**Consultation Response from KC,
Highways Development Management**

2023/92061 119, Huddersfield Road, Mirfield, WF14 9DA

Discharge of conditions 6 (right-turn lane), 8 (Construction Management Plan), 10 (electric vehicle charging), 11 (Phase II report), 18 (temporary drainage), 20 (surface water drainage), 22 (hardstanding drainage) and 27 (external lighting) of previous outline permission 2019/92221 for demolition of existing buildings and erection of Class E retail unit, access, car parking, servicing, landscaping and associated works (all matters reserved other than access)

A proposed temporary site set up is indicated below, showing traffic management, site set up, parking, storage, and recycling areas.

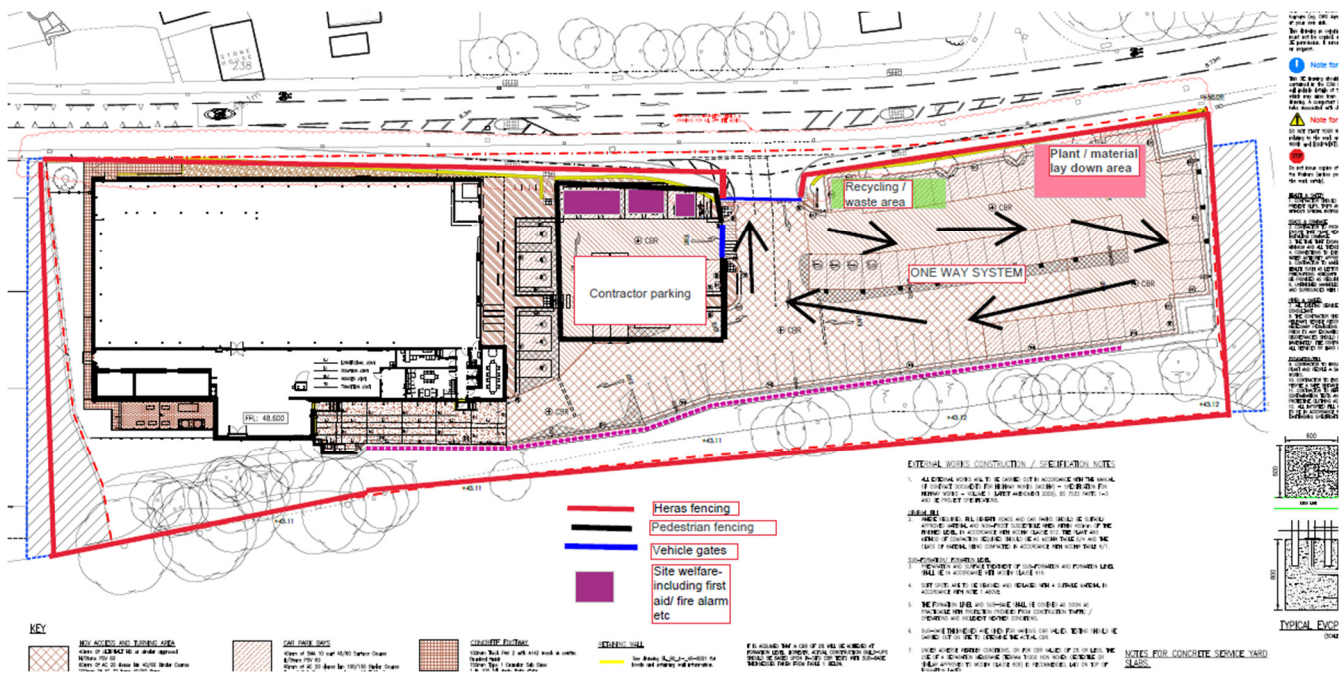
1, The times of use of the access for construction should be amended to avoid the peak hours for traffic.

2, No proposals to demonstrate how the highway will be kept clear of mud/debris are provided.

This condition should not therefore be discharged.

Project:		HUDDERSFIELD ROAD MIRFIELD	
Client:		ALDI STORES LTD	
Drawing:		SECTION 278 WORKS GENERAL ARRANGEMENT	
Drawn By:	TS	DATE:	05/05/2022
Checked:	RC	Scale:	1:250 @ A1
Drawing No:	AMA/40110/D/001	Rev:	1

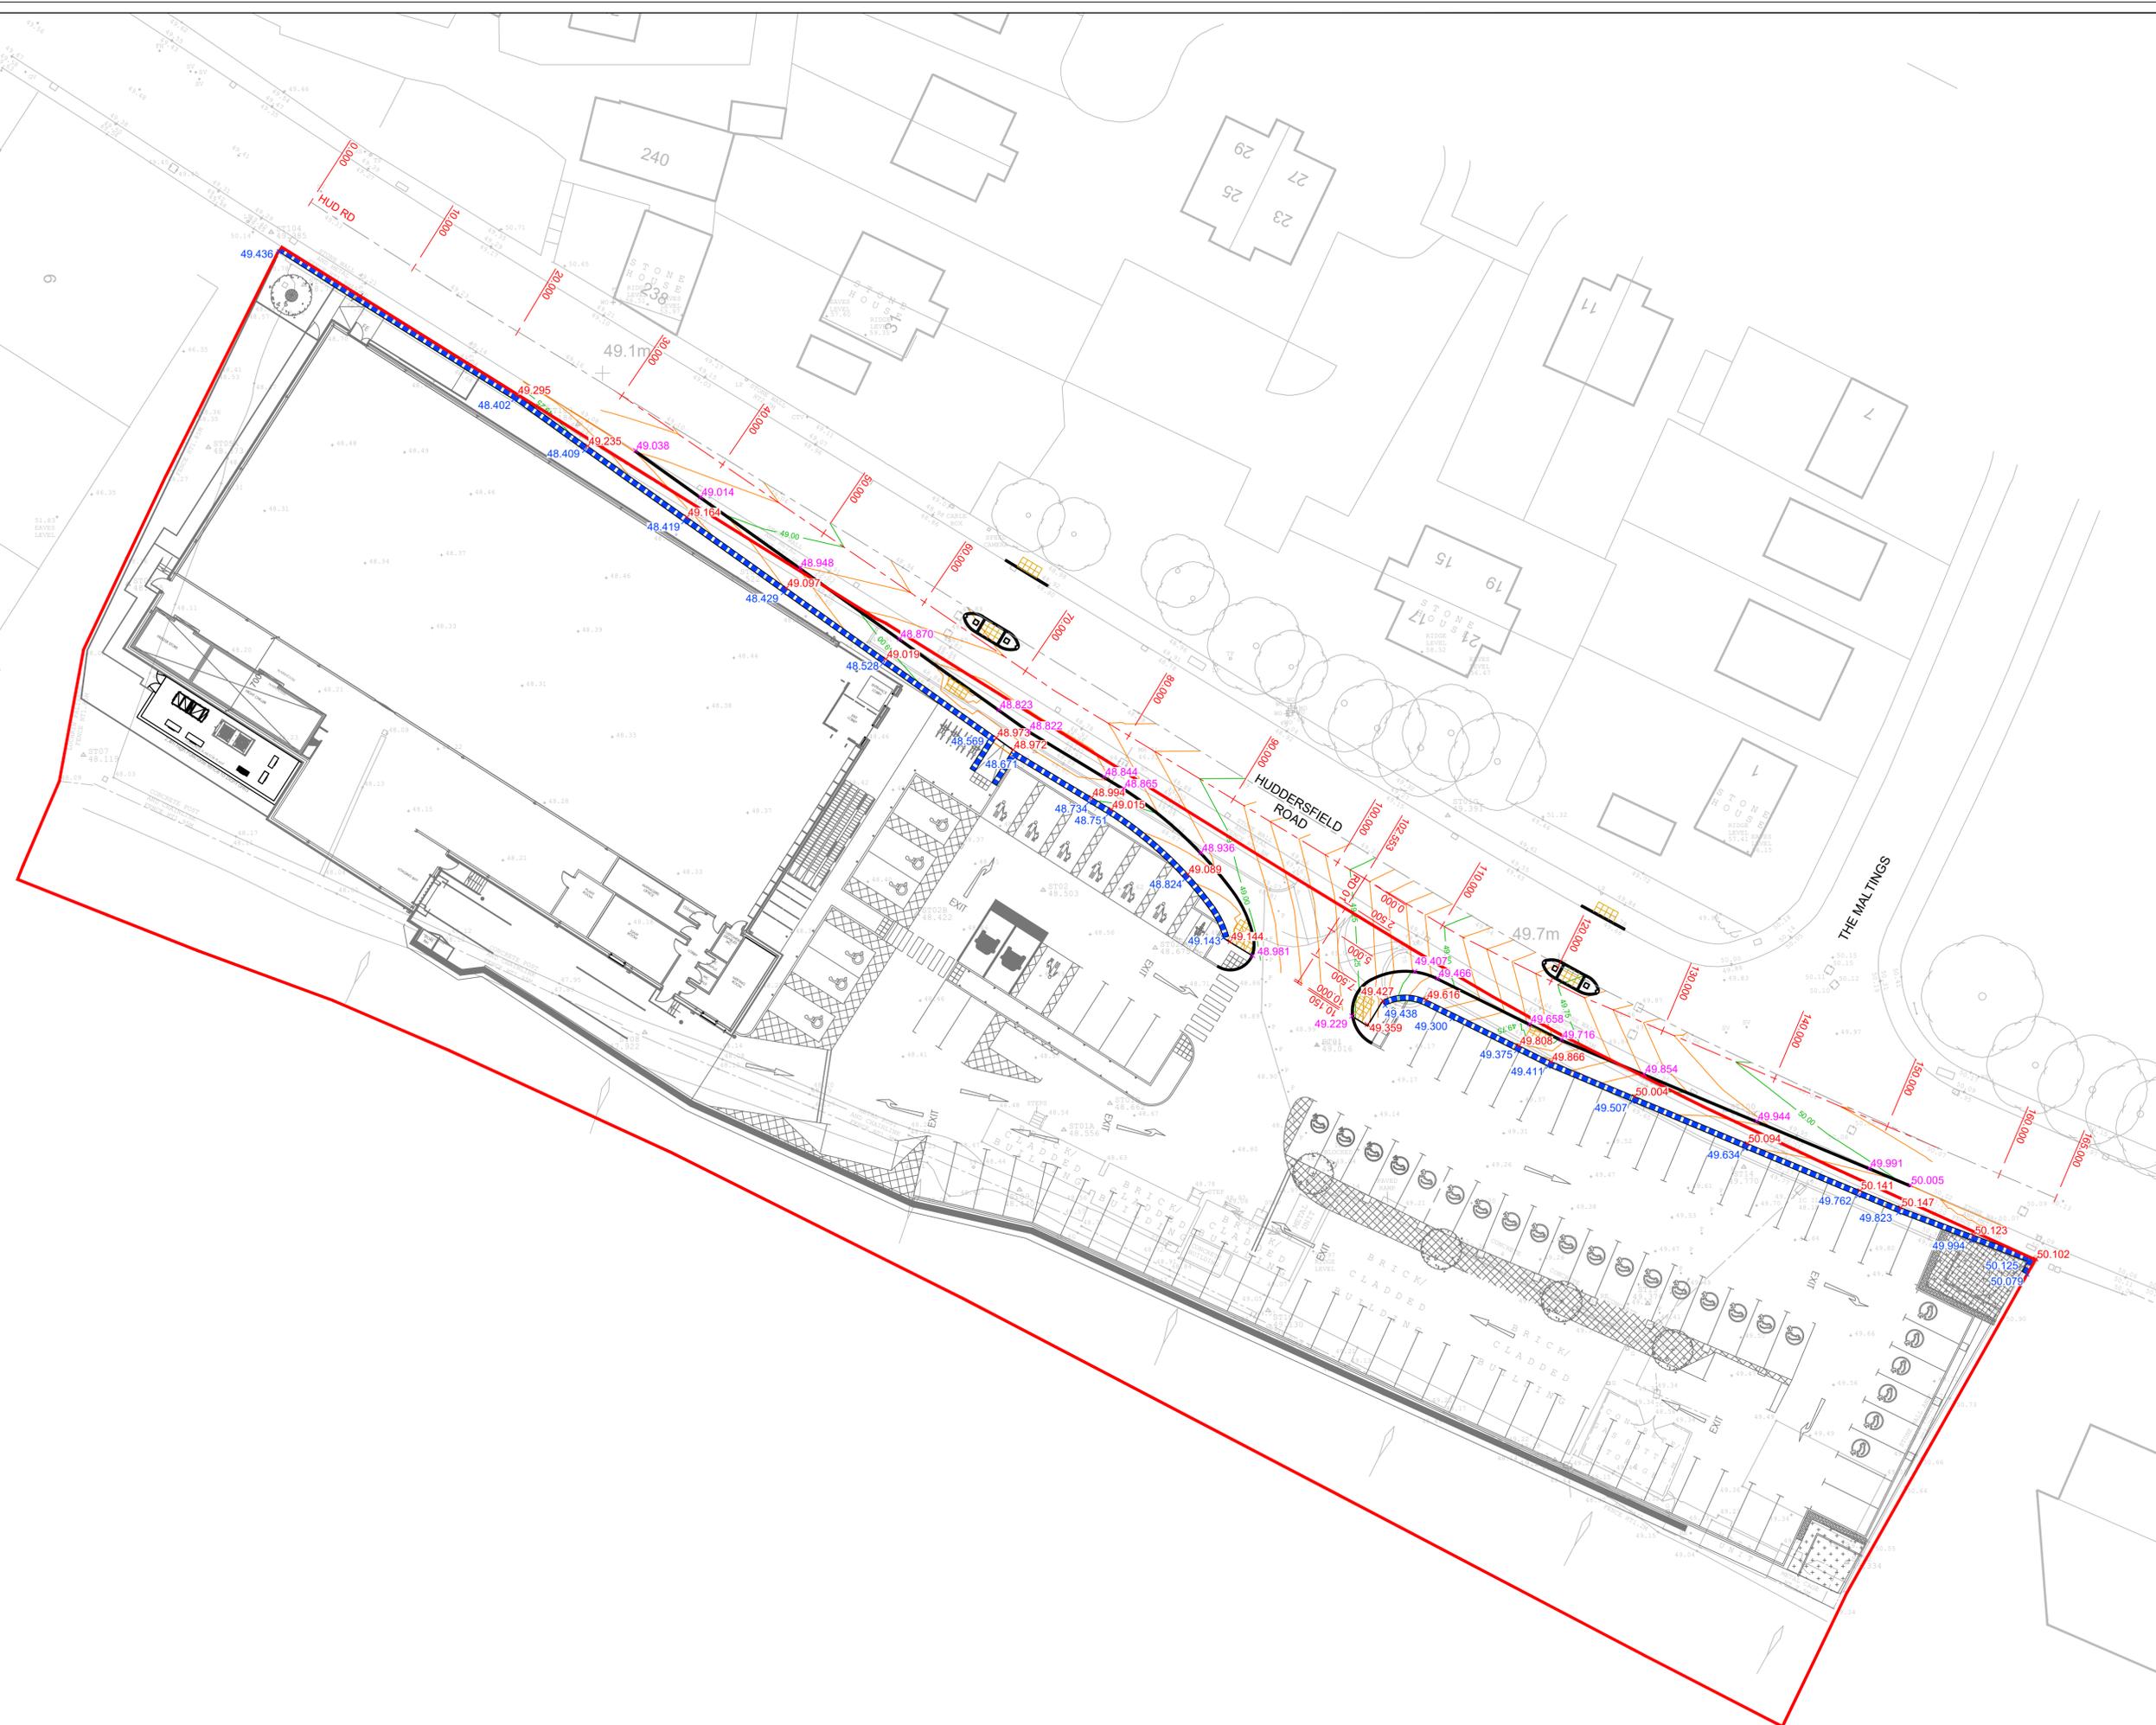
The Highway Design Section confirm that section 278 technical approval has not yet been granted and this condition should not therefore be discharged.
